EPC STORMWATER REVIEW COMMENTS
 IN ORANGE BOXES WITH BLACK TEXT

EL PASO COUNTY GRADING AND EROSION CONTROL PLAN CHECKLIST

**OVERALL INITIAL
 EROSION
 CONTROL PLAN**

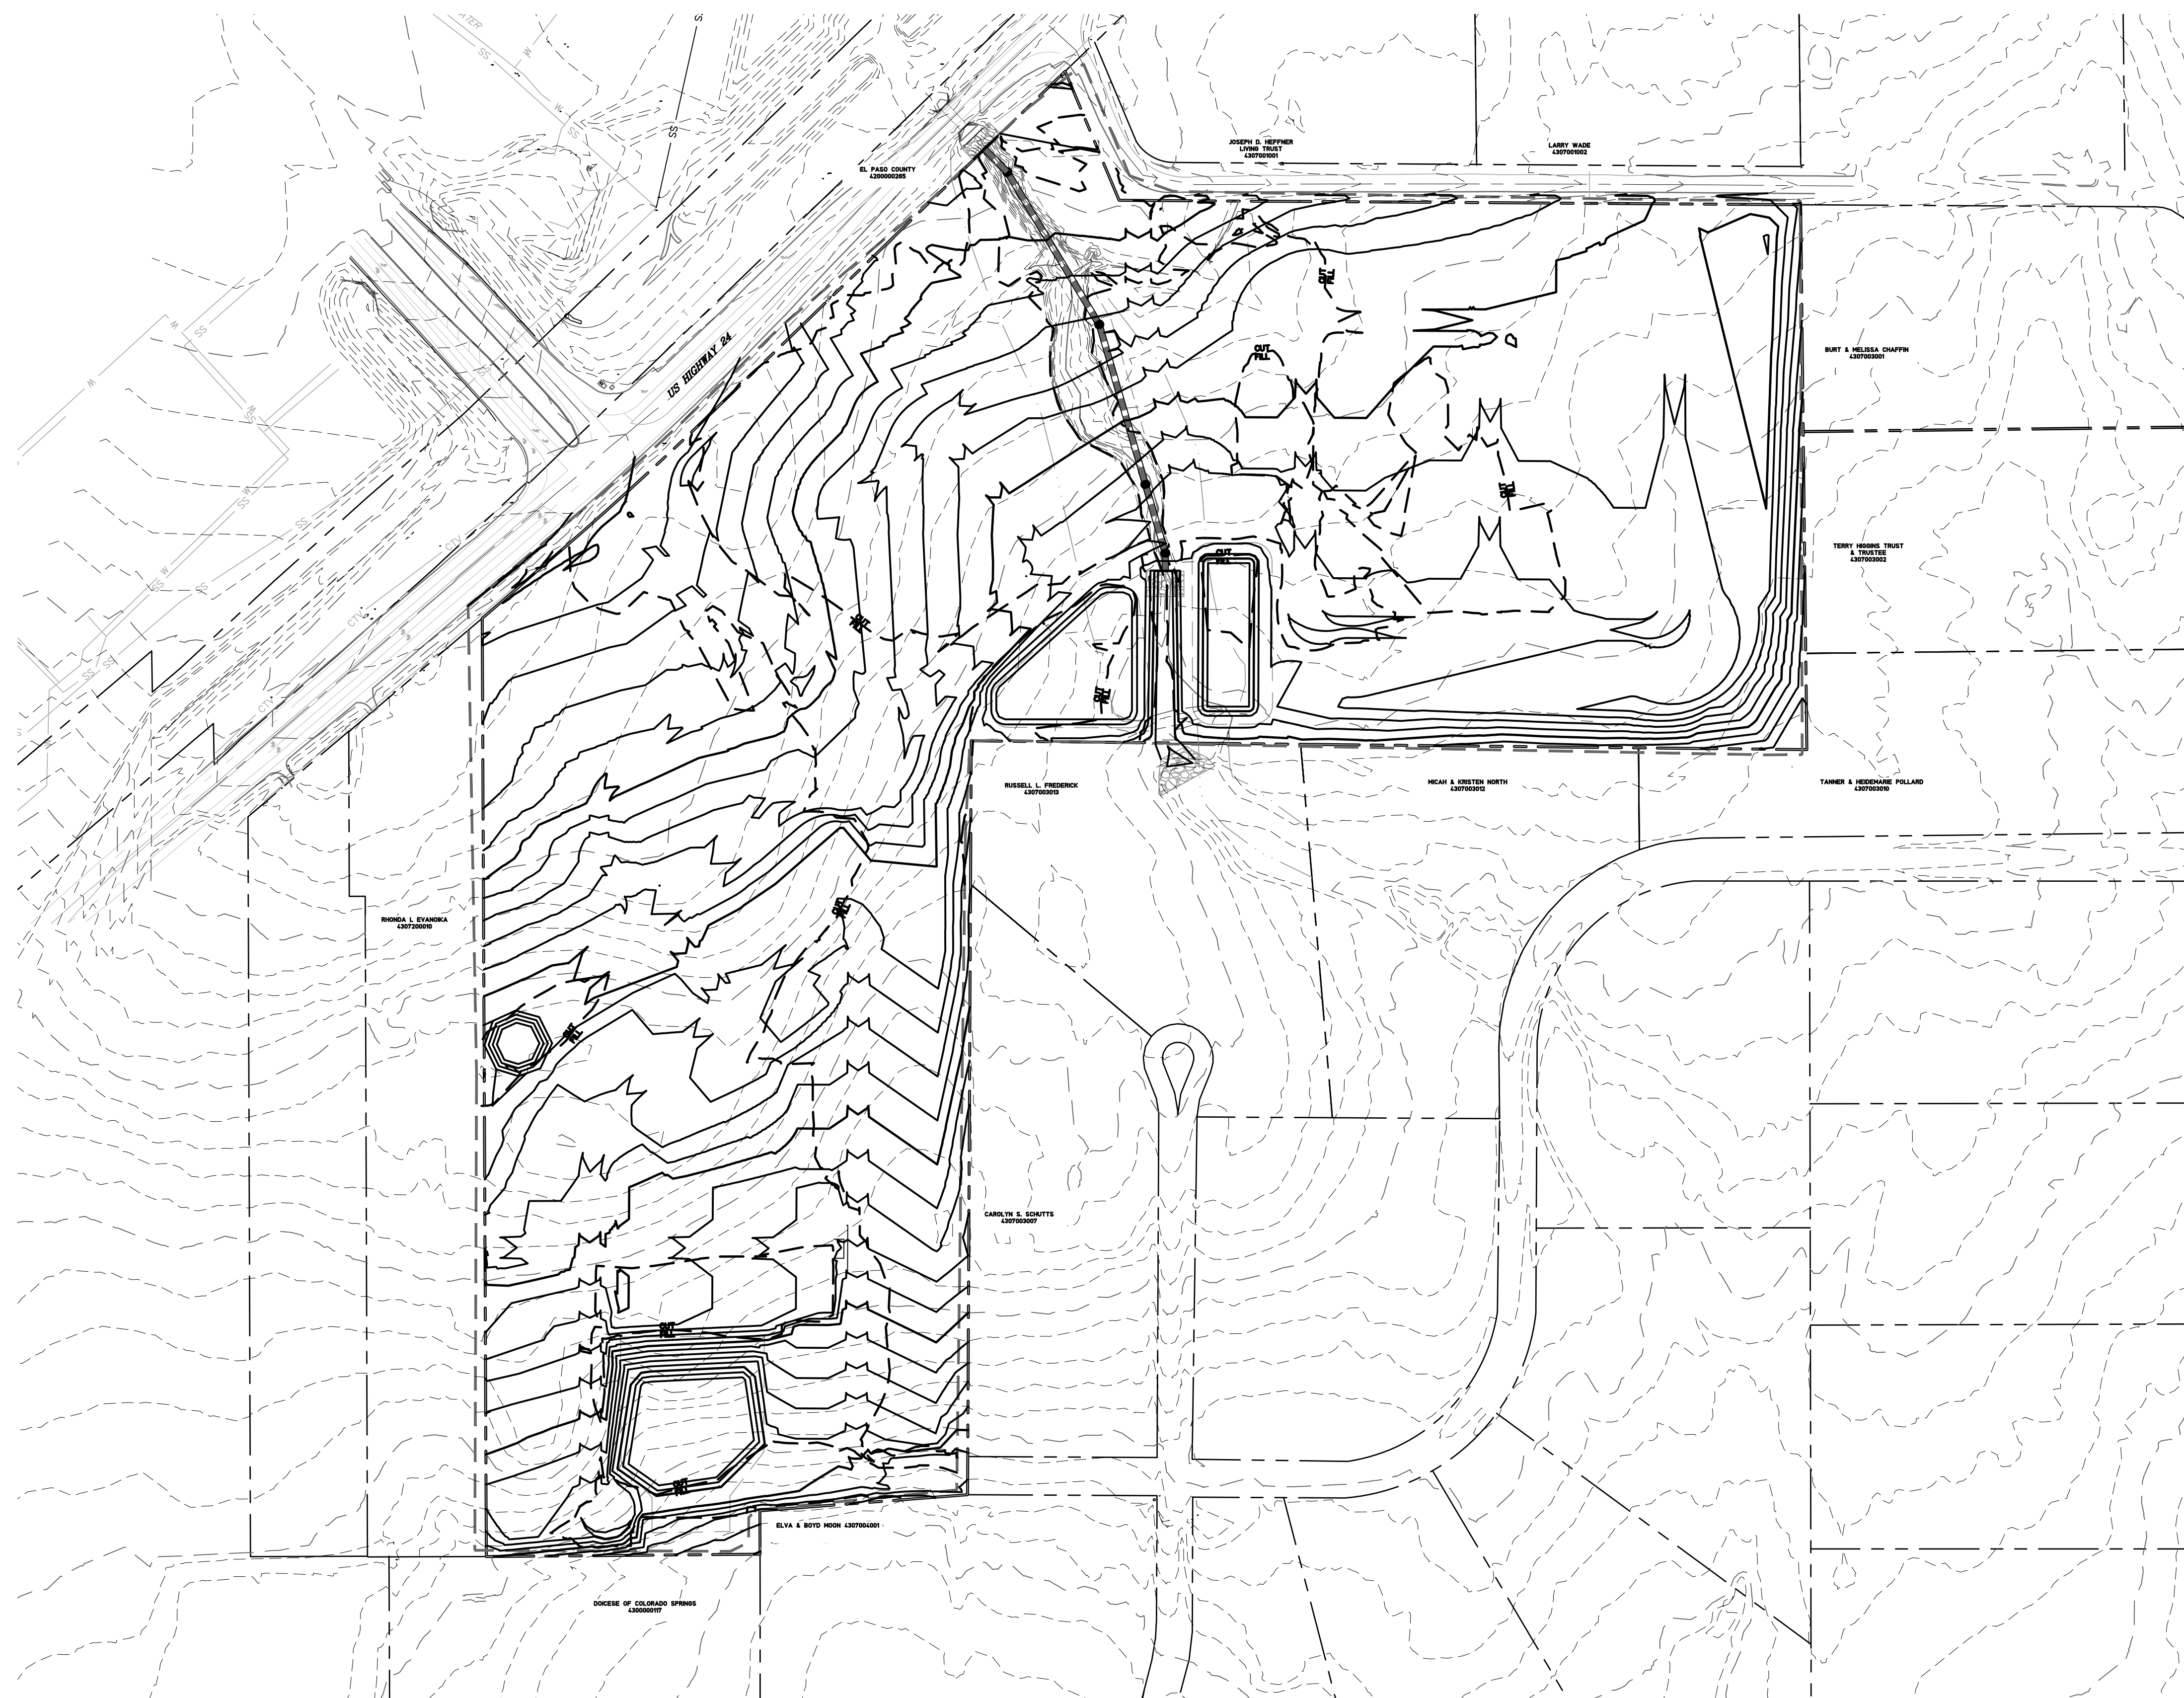
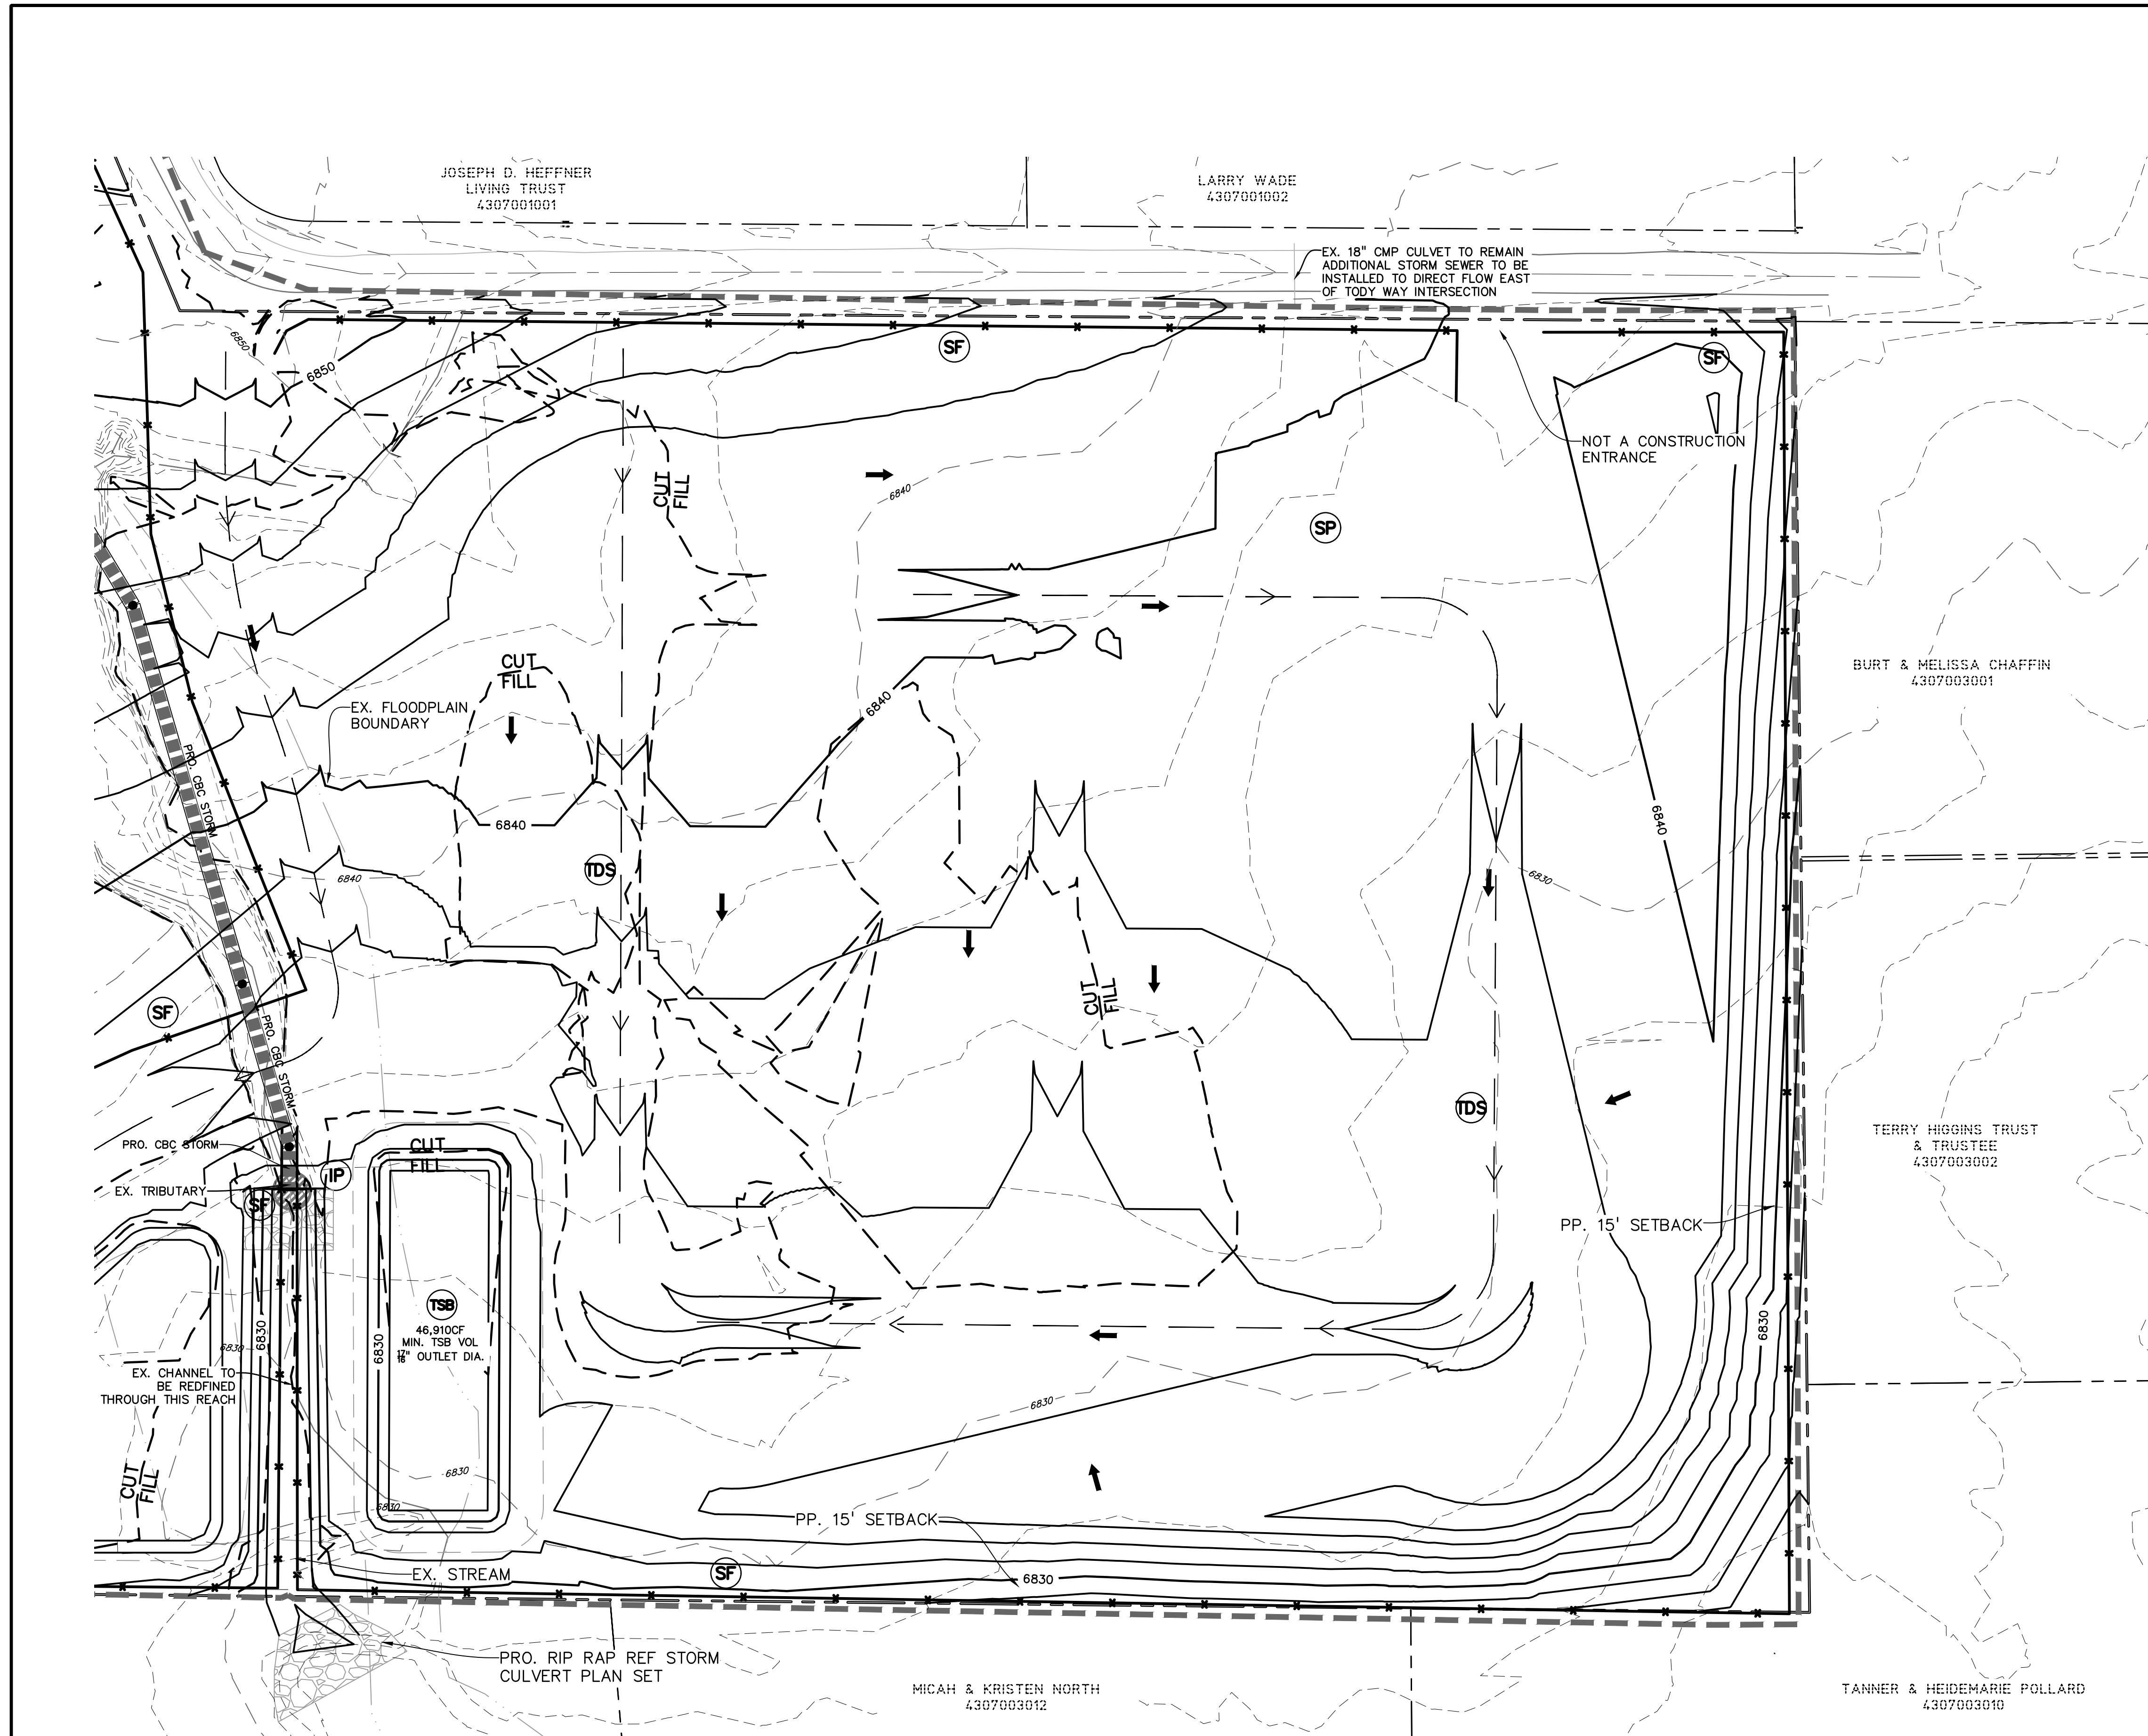
v	All proposed temporary construction control measures, structural and non-structural. Temporary construction control measures shall be identified by phase of implementation to include "initial," "interim," and "final" or shown on separate phased maps identifying each phase		N
w	Vehicle tracking provided at all construction entrances/exits. Construction fencing, barricades, and/or signage provided at access points not to be used for construction		Y
x	Temporary sediment ponds provided for disturbed drainage areas greater than 1 acre		Y
